Application Reference: 6/2017/2625/COND

Proposed development at: Plot 4100, Gypsy Moth Avenue, Hatfield Business Park, Hatfield.

Proposal: Submission of details pursuant to conditions: 5 (details of new roads, accesses, cycleways and footpaths), 6 (Surface water drainage scheme), 7 (site investigation), 9 (Reptile Survey), 12 (details of flood lighting and external lighting) and 13 (details of open storage) on planning permission 6/2015/2043/OUTLINE dated 05/07/16

Drawing title	Status, Drawing number & revision	Amendments
Proposed Site Plan	3280/ 130 5	Site Entrance re-worked
Drawn by	Checked by	A1 Scale
EM	MR	1 : 500
		A3 Scale
		Date
		15/12/2017
		14:41:00
		Status
		TENDER

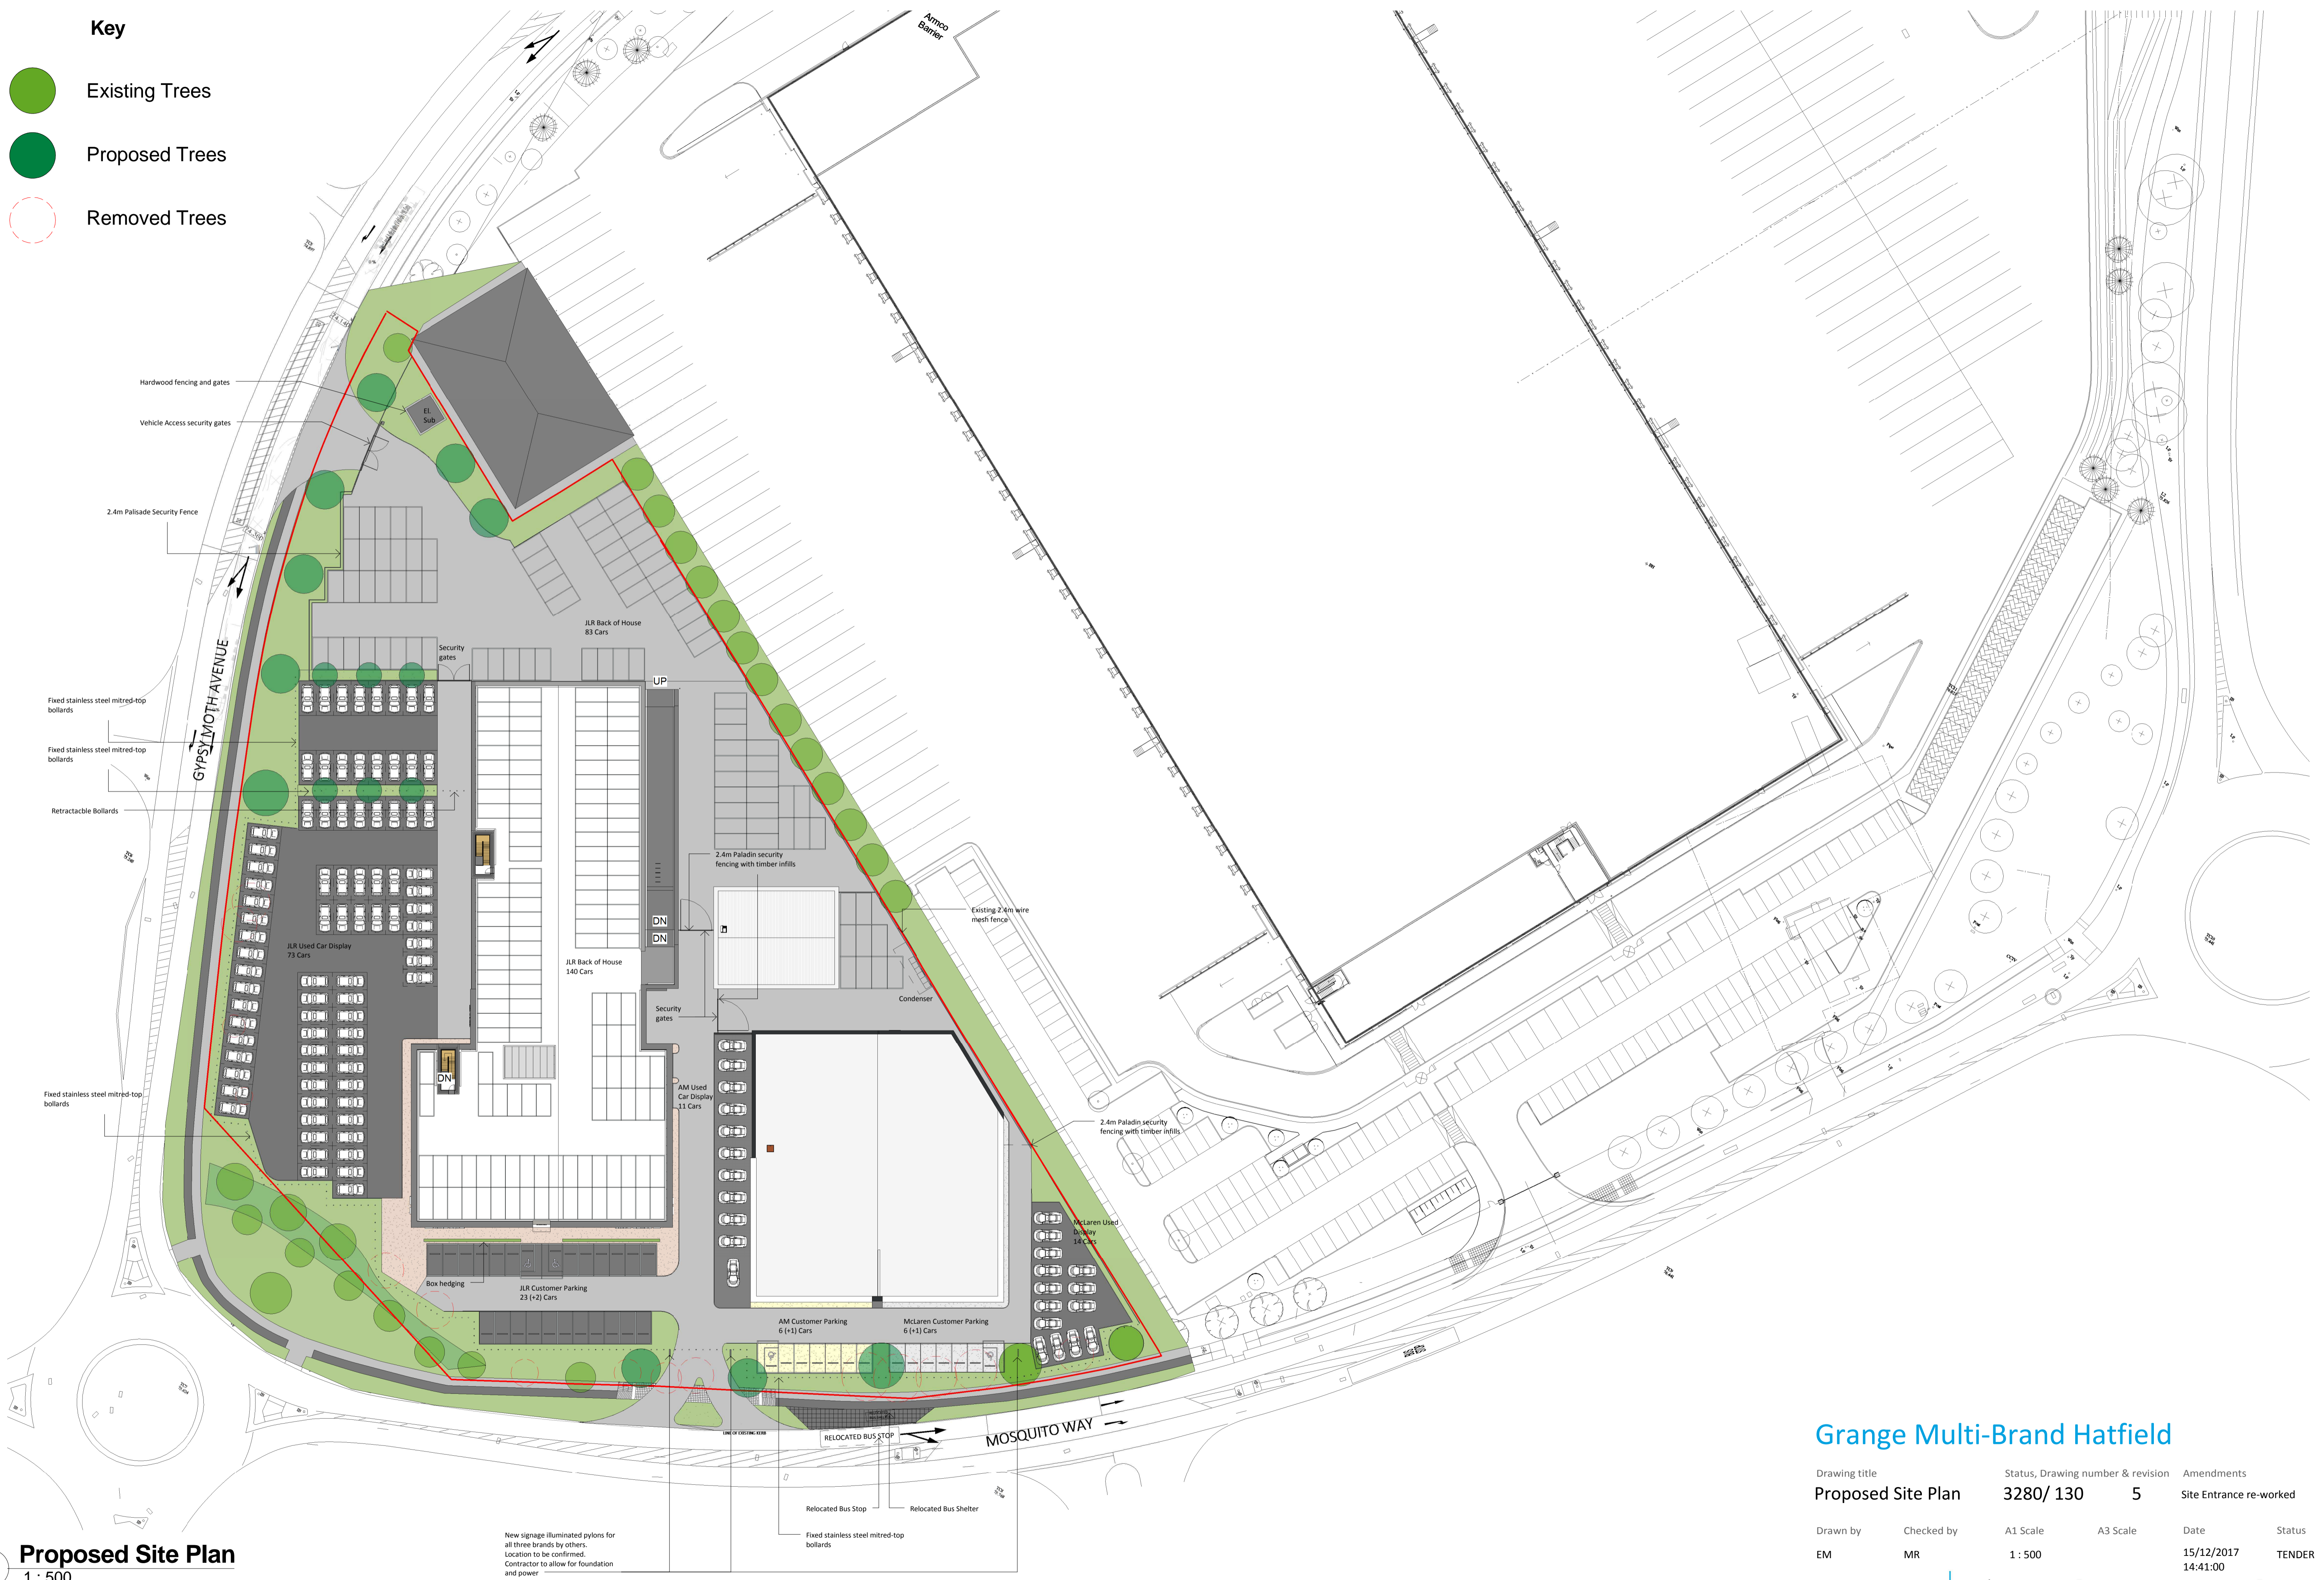
Details shown on drawing 3280/130 relocate the bus shelter to a point closer to the new access. The justification for this is unclear. There are no highway benefits to its relocation and concern is voiced that it is too close to the proposed new access. There have been no discussions with the Highway Authority in regard to proposals to relocate the bus shelter. The distance moved is insufficient for it to have any benefit in terms of accessibility to stops (walk time). The relocated position provides no benefit to vehicles on Mosquito Way if a bus is in position at the stop, still providing no opportunity for safe overtaking. No evidence is available that alternative locations for the bus stop (east of junction of Trident Place / Mosquito Way) have been considered. Concern is voiced over downstream congestion impacting on the adjacent roundabout junction which would not be an issue if the stop was located further to the east. Given the above concerns, neither the Highway Authority nor the

Local Planning Authority are not satisfied that the suggested bus stop location is appropriate.

The provision of Kassel kerbing for the shelter, and the requirement to provide dropped tactile kerbing to serve the pedestrian crossing (refuge) on Mosquito Way in advance of right hand turn lane, presents concerns over the gradient of transition between these opposing levels in such close proximity to each other.

The Highway Authority remain concerned that the refuge is insufficient in width (at back edge) to accommodate cyclists safely. TA91/05 (DMRB) Provision for Non-Motorised Users Summary directs "6.19 ...The preferred crossing width for cyclist refuge islands is 3.0m to 4.0m (2.5m at constrained locations)."

Drawing 3280/130 Rev 5 features inconsistencies – whilst described as 1:500 at A1 – the scale bar does not conform to this. Introducing concerns for scaling.

Whilst corduroy tactile is provided at both ends of the segregated cycleway either side of the new access, and therefore the crossing is unsegregated shared space, this shall introduce a departure from the desire line and introduce greater risk of conflict between pedestrians and cyclists by encouraging them both to gravitate towards the wider area provided in the refuge. In the absence of a Stage 1 RSA demonstrating that the use of the refuge island for all road users the Highway Authority remain concerned with the proposals.

Reference to vehicle tracking, drawing ITB13336-GA-007 demonstrates that opportunities exist to increase the size of the refuge without affecting the general location of the access / egress.
